Planning Application No: 3/2026/0655

Proposal: Advertisement consent for installation of one externally illuminated projecting sign to identify Barrow Village Hall.

Location: 23-25 Old Row Whalley Road Barrow BB7 9AZ

Signage Projecting Sign

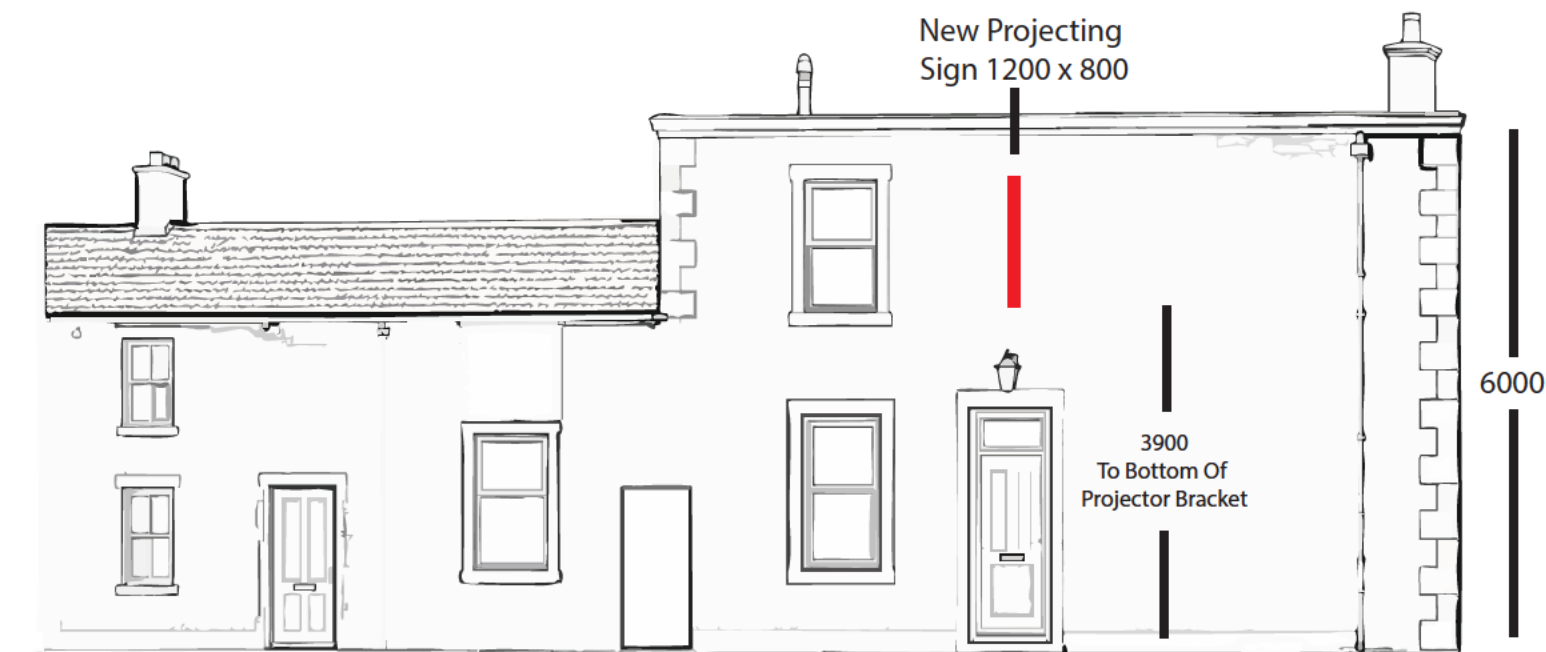
- The limits of the illuminance shall not exceed 600 candela per square metre. Reason: To avoid glare, dazzle or distraction to passing motorists.
- Any external source of lighting shall be effectively screened from the view of a driver on the adjoining public highway. Reason: To avoid glare, dazzle or distraction to passing motorists.
